**Consultation Response from KC,
Trees****2024/92779 land at Providence Street, Earlsheaton, Dewsbury, WF12 8HZ****Outline application for residential development****Date Responded: 09/07/2025****Responding Officer: Hazel Irving****Responding Ref: 02/24**

DRAWING:
ILLUSTRATIVE MASTERPLAN

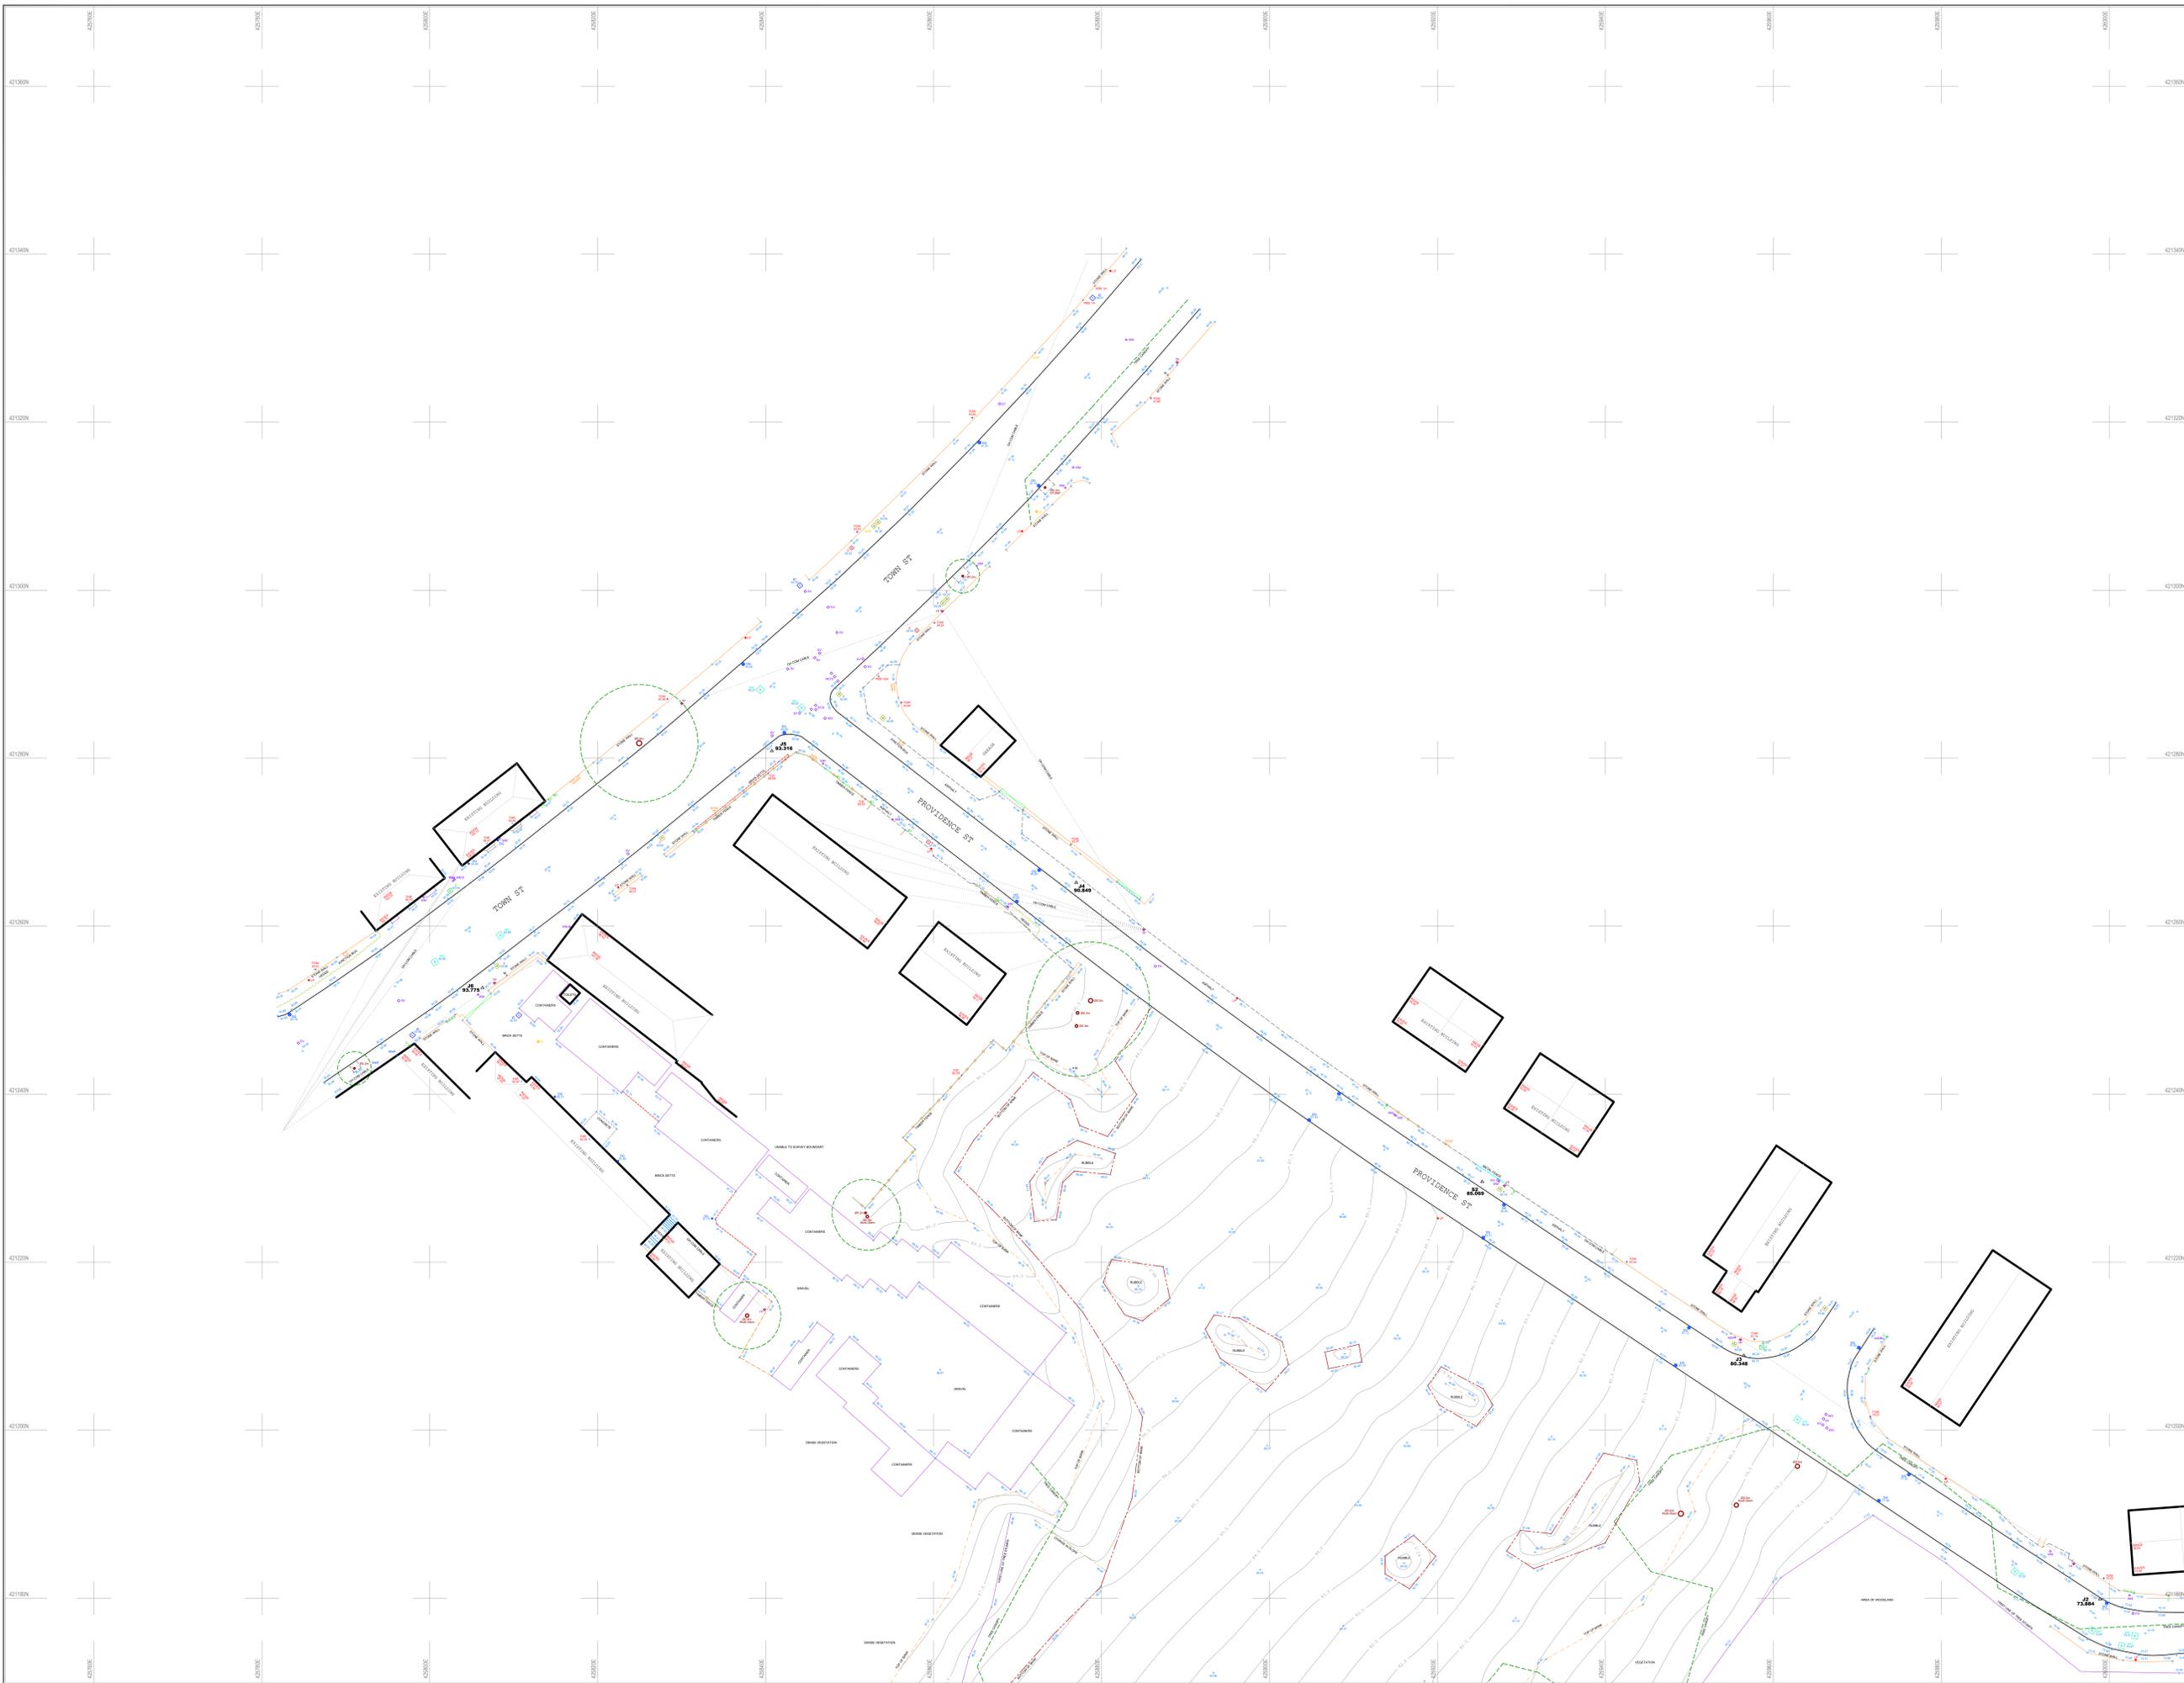
Five new trees are proposed to be planted along the frontage of Providence Street, to mitigate loss of the removed tree belt. These would offer some amenity value and screening into the site. However realistically, the space allowed between the highway and the buildings is limited within the proposals and these trees would be planted in-between driveways, which would also limit the available rooting area. It is unlikely that there is adequate space for even smaller tree species, such as rowan or birch to mature in these locations without conflict or removal by residents.

Instead, we would expect to see a generous verge on the frontage of Providence Street to accommodate tree planting to replace the tree belt which has been removed without the appropriate consent. There must be ample space to accommodate larger tree species, which would capture more carbon, live longer and offer more in the way of ecosystem services and habitat value. Therefore, the design cannot include plots directly off Providence Street.

The illustrative masterplan shows tree planting throughout the development located beside driveways, which again, would constitute smaller species, which are unlikely to be retained due to foreseeable conflicts with future residents. Many of these are sited south of proposed buildings and would cast shadow on the homes. Tree planting locations must be sustainable to reasonably ensure future tree cover within the site.

- AMS and Tree Protection Plan.
- 10-year woodland management plan, detailing replanting, management interventions and woodland enhancements.
- A detailed planting scheme, including sustainable tree planting locations with appropriate species and a landscape management plan to outline how new trees will be maintained.
- KC trees will amend the TPO 02/24 to include the agreed landscaping scheme and enhanced woodland.
